# Stonestreet Green Solar

## Responses to Deadline 5 Submissions

PINS Ref: EN010135  
Doc Ref. 8.20  
Version 1  
Deadline 6  
April 2025

Figure 13.3: PRow Survey Results - Daily PRow Trips

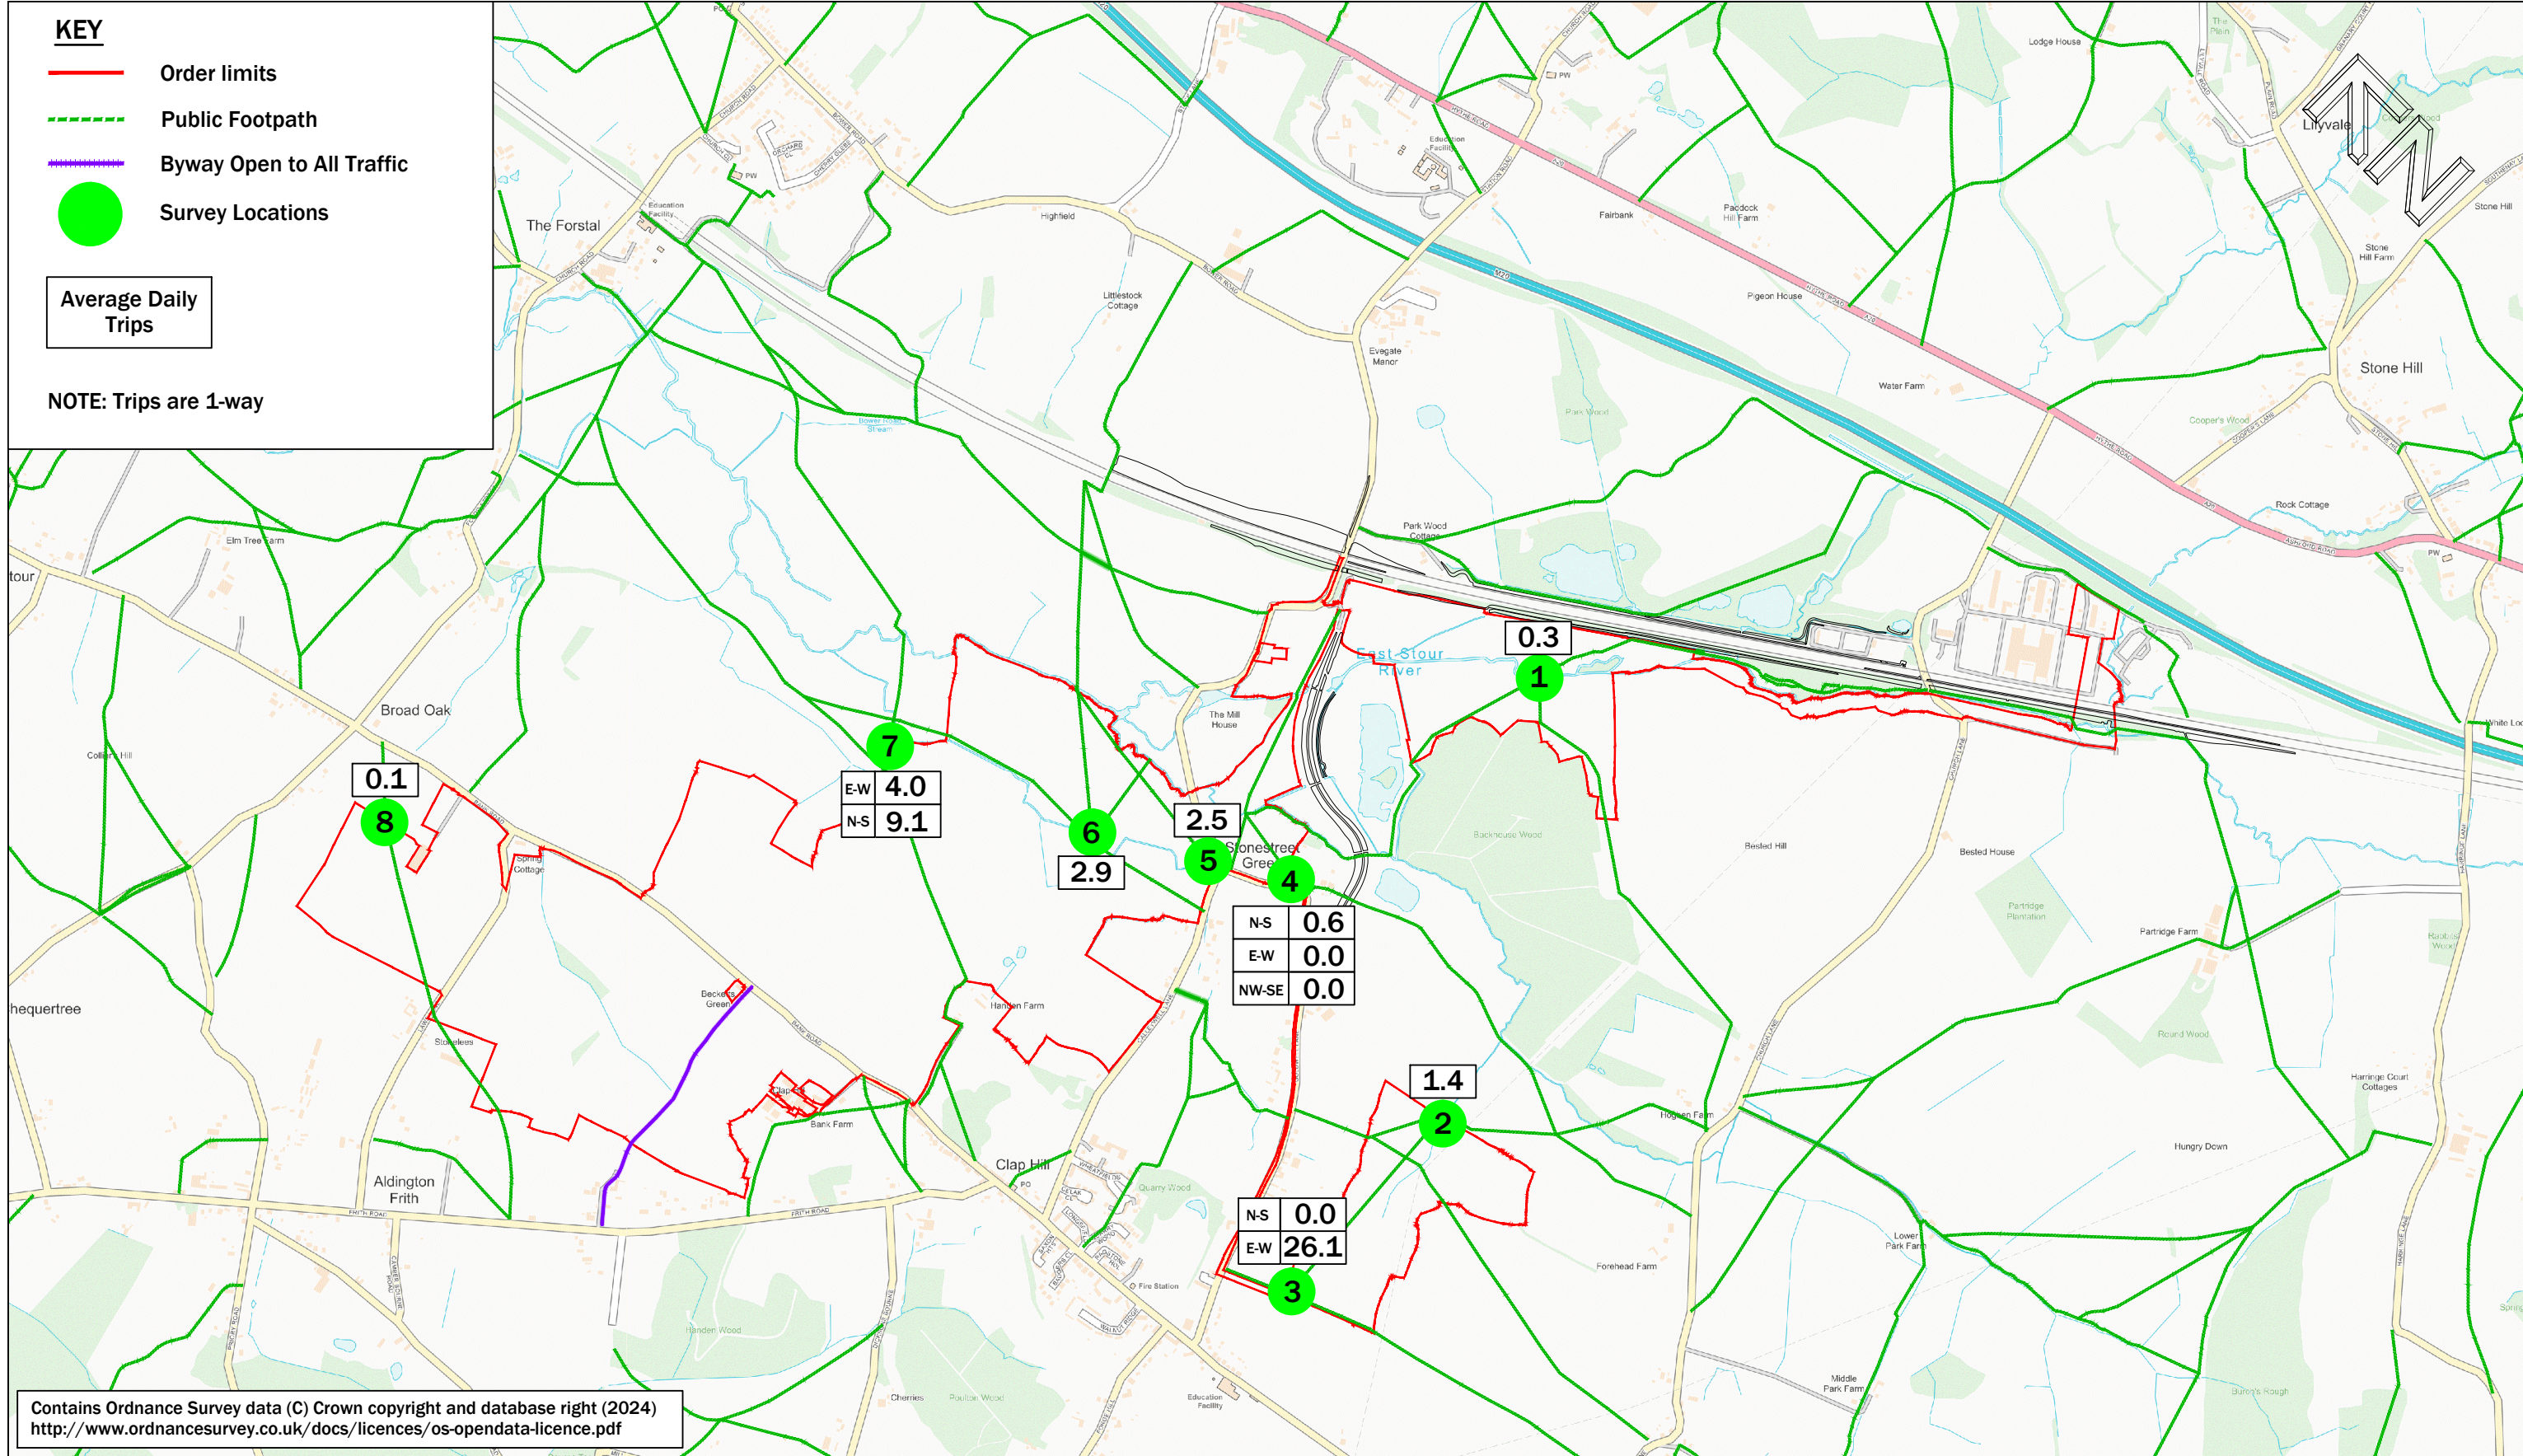
Ref	Summary of Interested Party's Comments	Applicant's Response
	<p>2020 used an estimated 6 million litres of water, compared to the 228,000 litres the Applicant plans to make available at Stonestreet Green (for each of the 26 battery enclosures). The Applicant has not demonstrated how it has used this information and that from other BESS incidents to inform its decision on the volumes of water it proposes to provide to cool and manage a BESS fire. We therefore believe that the Applicant should be asked this question.</p>	
<b>PROW</b>		
Page 6	<ul style="list-style-type: none"> <li>We anticipate that Mr Andrew Swarbrick and both KCC and ABC will be responding on matters relating to PROW.</li> <li>We have made representations previously on PROW and will only add here that the assertion by the Applicant that there is "limited connectivity between the two villages" only serves to illustrate the lack of understanding it still has about the PROW network.</li> <li>The plan in the submission illustrates the network of long-established definitive footpaths that connect the two parishes. It was the even greater connectivity that would be afforded by the provision of another cycle/riding route that both communities were seeking in respect of which the Applicant has talked much and done little.</li> </ul>	<p>The Applicant's comment that "<i>there is limited connectivity between the villages</i>" is evidenced by the fact that the Applicant's PROW user survey shows the local PROW network is relatively lightly used and offers primarily recreational routes.</p> <p>It is not a statement that denies the existence of footpaths "between the two parishes" – and the Applicant has considered origin and destination when assessing the options for diversions on those links including AE 370 and AE 377, which as assessed in <b>ES Volume 2, Chapter 12: Socio-Economics (Doc Ref. 5.2(B))</b> <a href="#">[REP1-024]</a> do not result in significant adverse connectivity effects.</p> <p><b>ES Volume 3, Figure 13.3: PROW Survey Results - Daily PROW Trips (Doc Ref. 5.3)</b> <a href="#">[APP-056]</a> shows the total PROW trips per day in graphical form. The full survey results are provided in <b>ES Volume 4, Appendix 13.6: PROW User Survey Results (Doc Ref. 5.4)</b> <a href="#">[APP-112]</a>. Paragraph 13.5.50 of <b>Chapter 13: Traffic and Access (Doc Ref. 5.2(D))</b> <a href="#">[REP3-012]</a> summarises the results.</p>

Ref	Summary of Interested Party's Comments	Applicant's Response
		<p>Fewer than 10 one-way trips per day were observed at six of the eight survey locations across the 7.5-day survey period with a number of locations not recording any usage during the survey period.</p> <p>In response to community requests for an offroad cycling route the Applicant has offered to make a financial contribution to the delivery of a cycle route between Aldington and Mersham, subject to appropriate landowner agreements and securing land permissions outside of the Order limits.</p> <p>AE 370 is the logical route of a proposed cycle route, linking the two villages and the Applicant has sought to design this route by minimising turns as a key consideration in its proposed diversion.</p>
